Overlook at Homestead Traffic Impact Study EPC PCD File No.: P-235 (LSC #S234200) August 15, 2023

RE: Overlook at Homestead
El Paso County, CO
Traffic Impact Study
LSC #S234200

# Stopping Sight Distance Exhibit

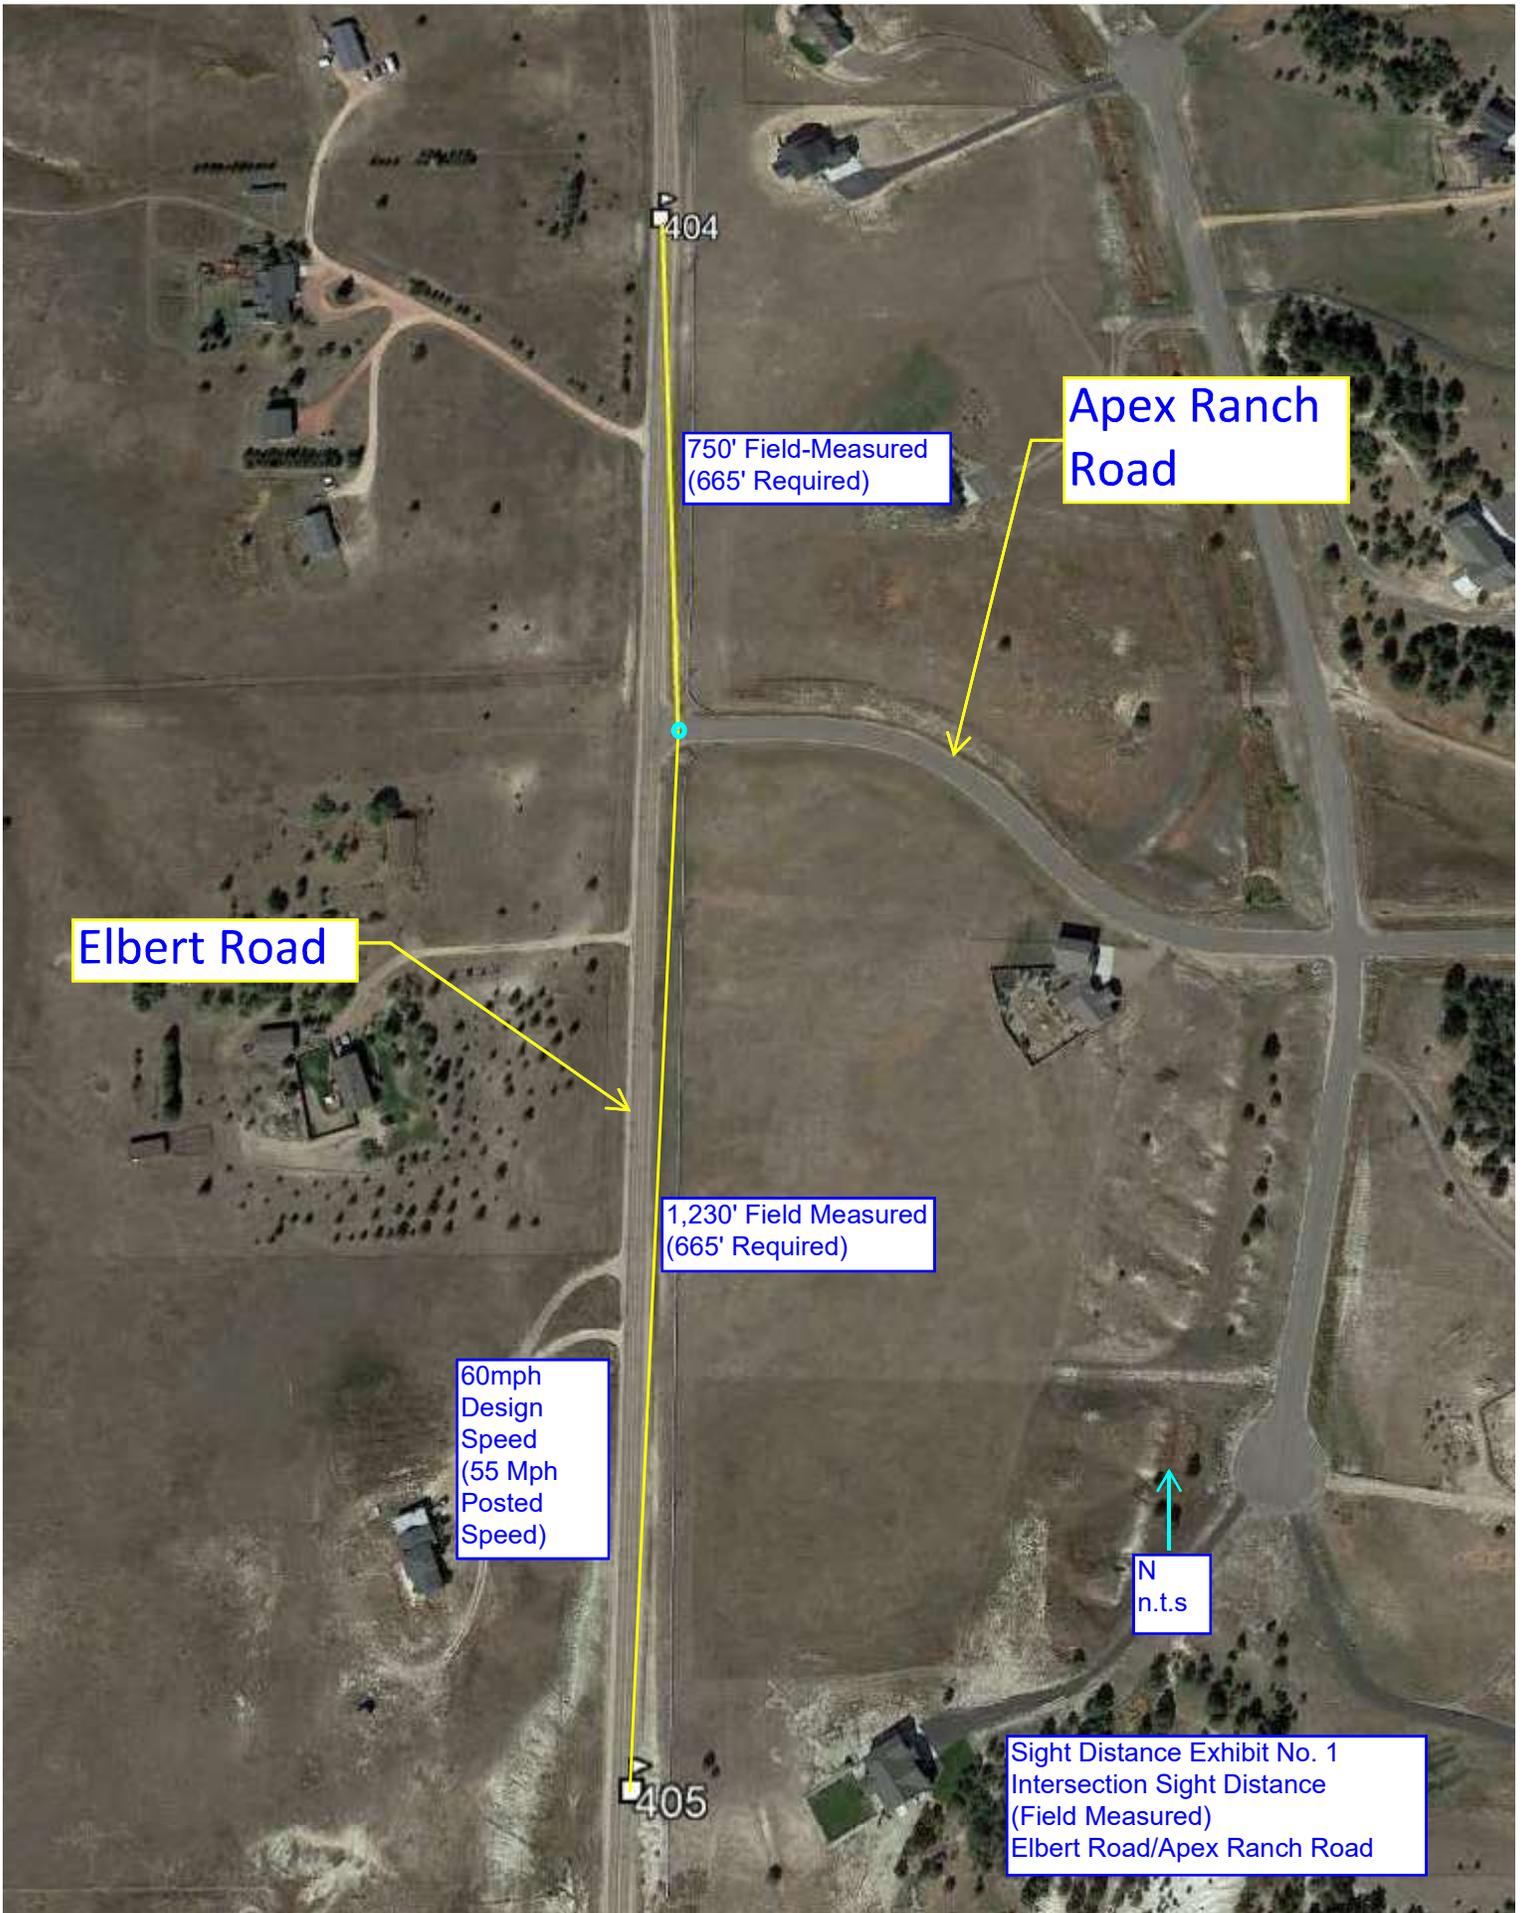
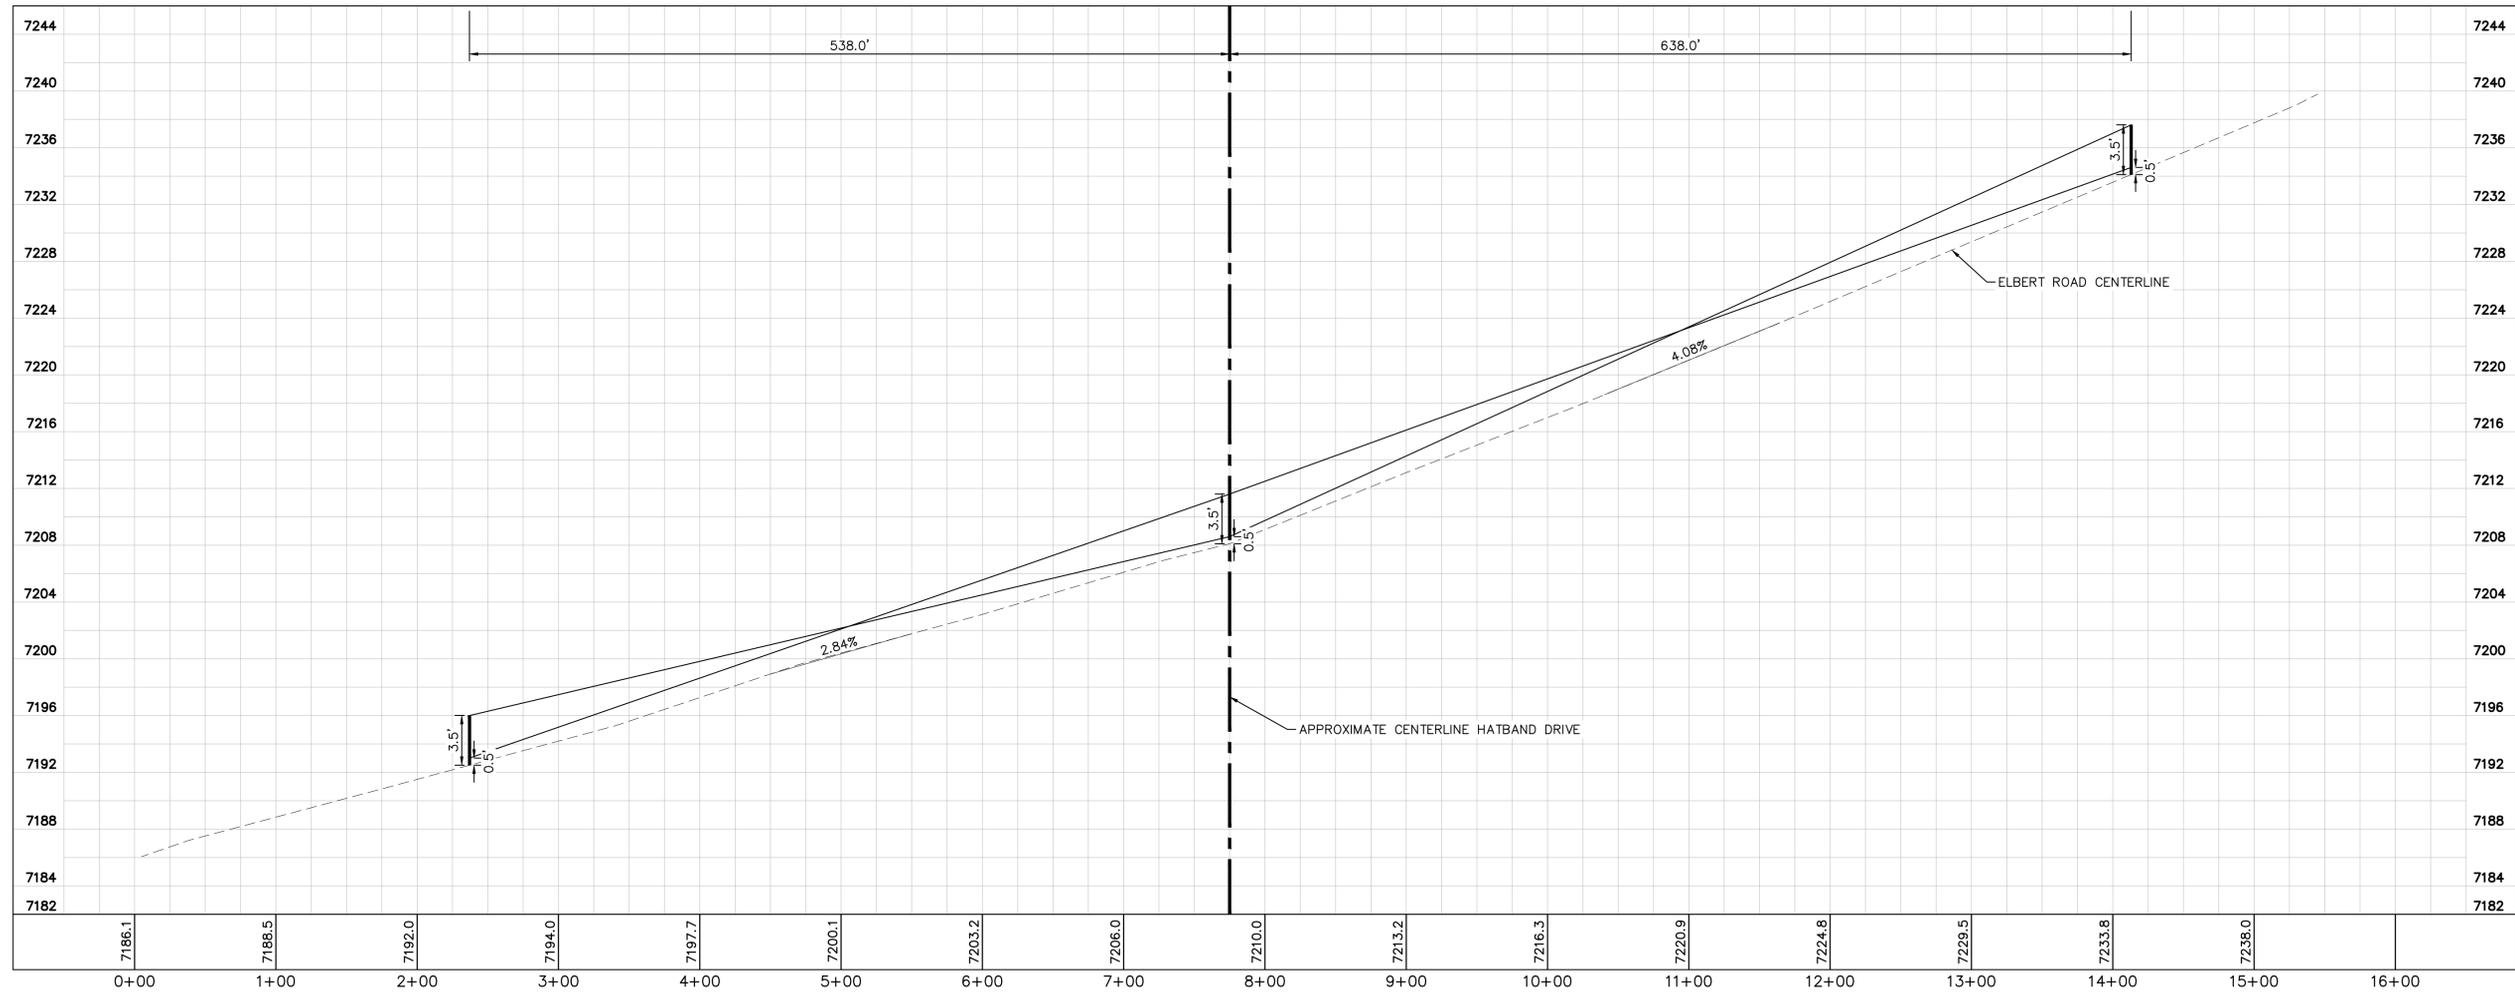
Please also analyze stopping sight distances. Are there any vertical curve/grade concerns that affect sight distance? please address
